Application for a Non-Material Amendment Following a Grant of Planning Permission

Erection of a one and a half storey extension and detached outbuilding

DC/22/01866

End677/02A (Proposed works to dwelling)

BLOCK PLAN (1:250)  
(DRAWN FROM MEASURED SURVEY)

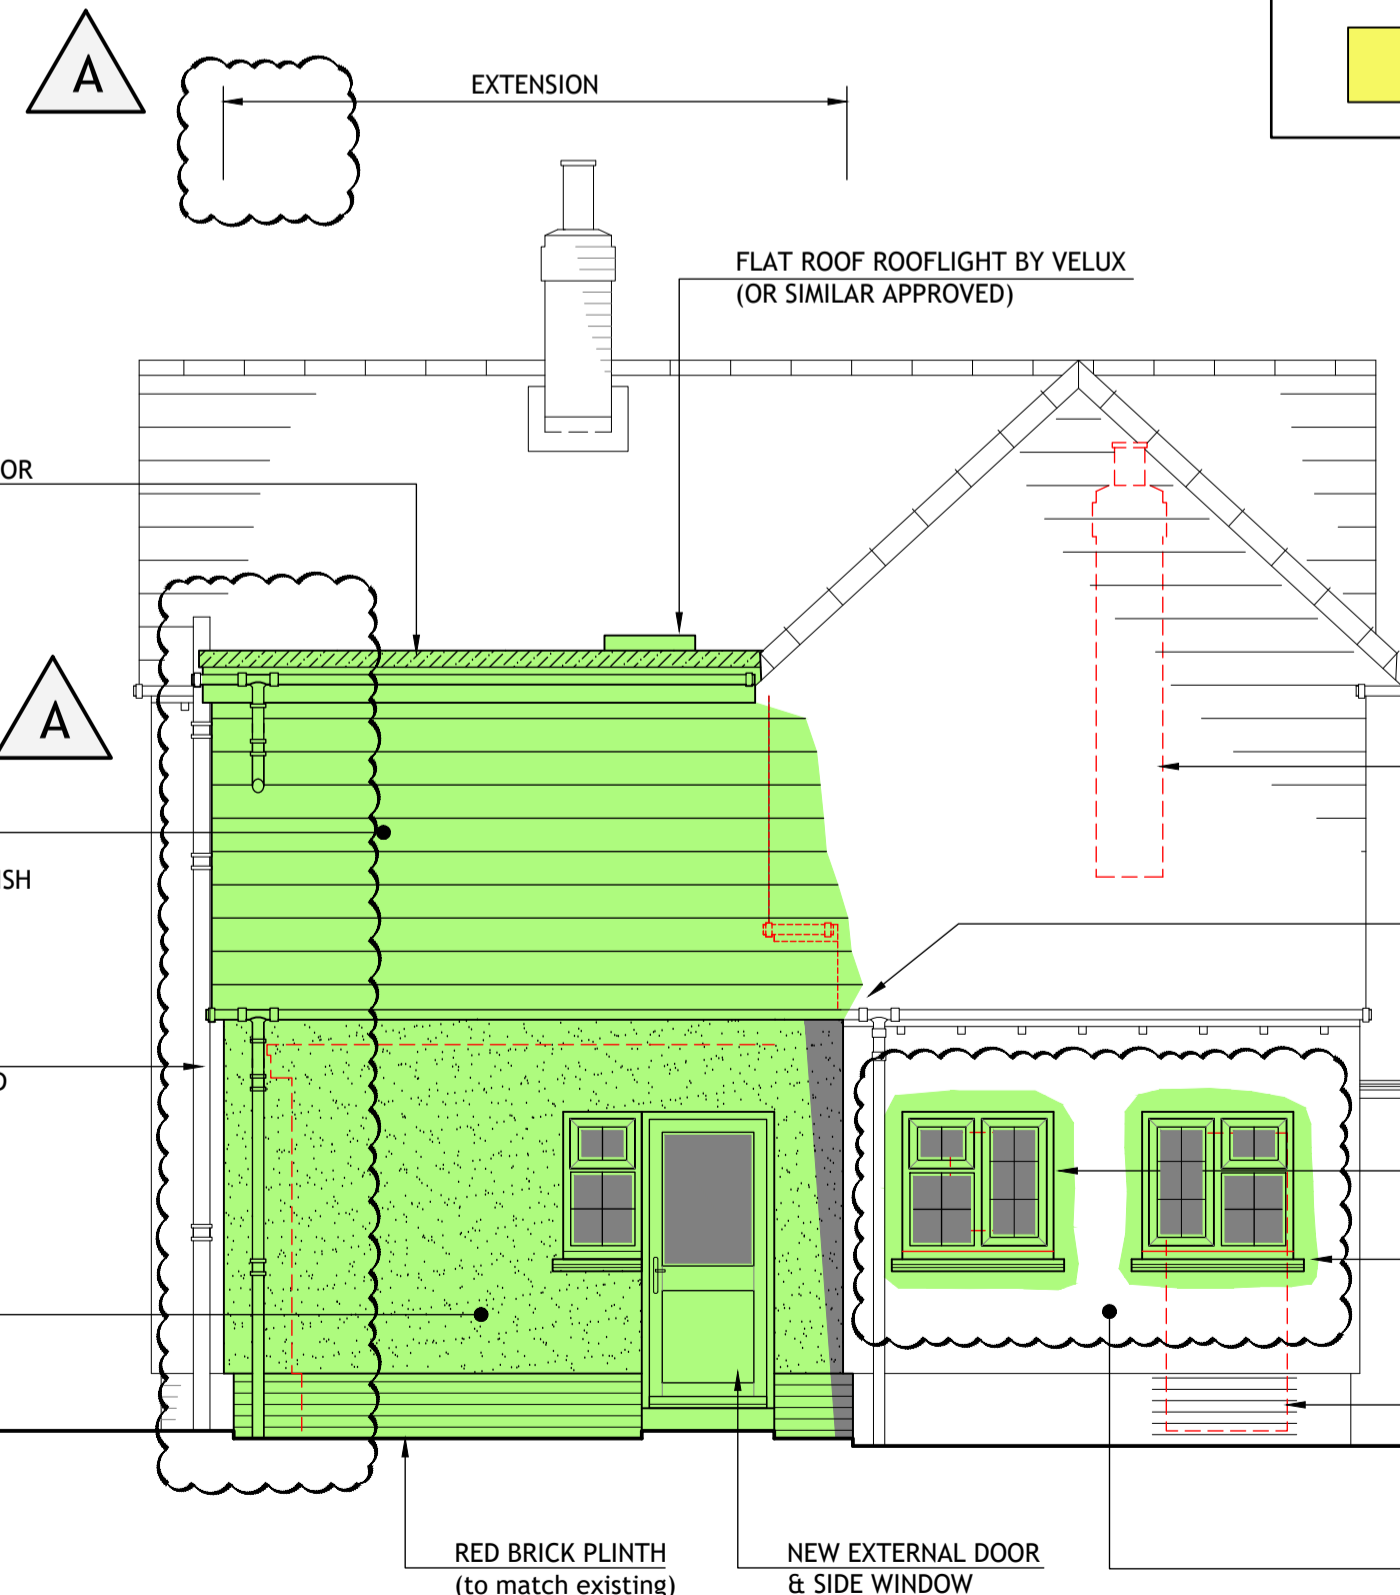
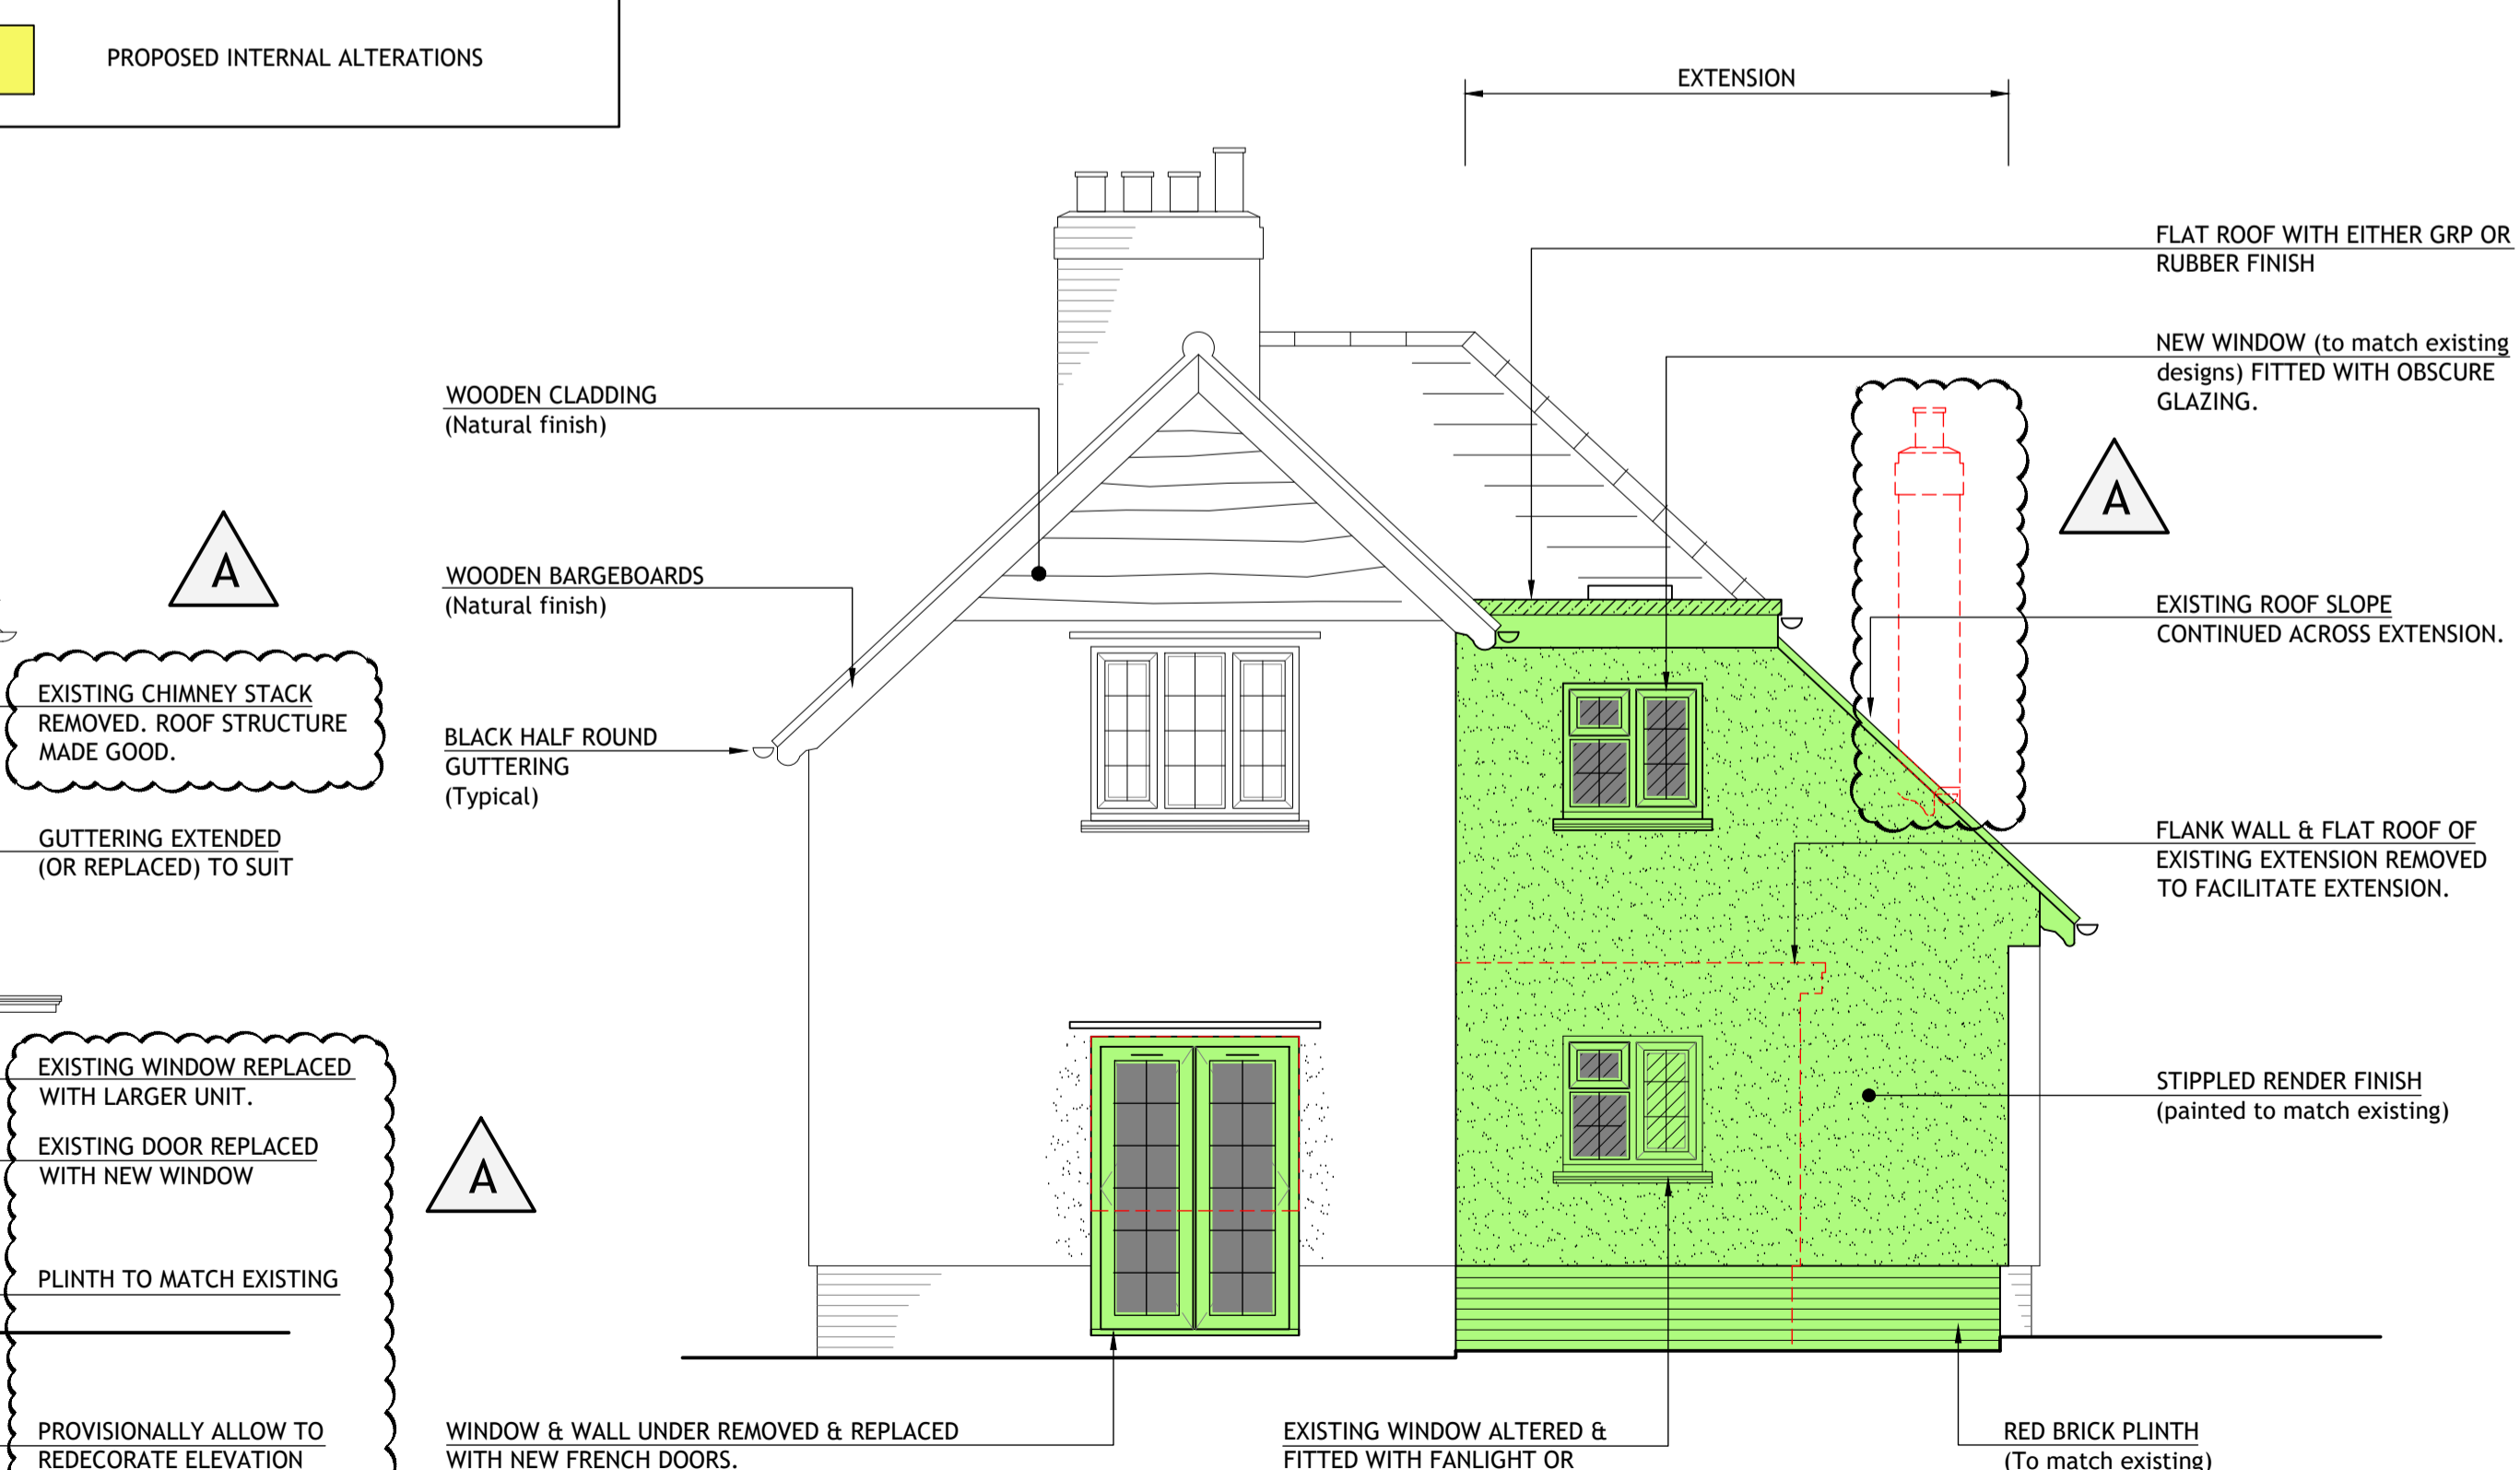
1. The rear extension is to be increased in depth by a further 450mm, albeit it is still articulated from the rear elevation of the cottage.
2. The existing door and window on the existing lean-to (south elevation) is to be replaced with 2x matching windows.
3. The existing narrow chimney stack emanating from the lean-to is to be removed.
4. The other changes are internal.
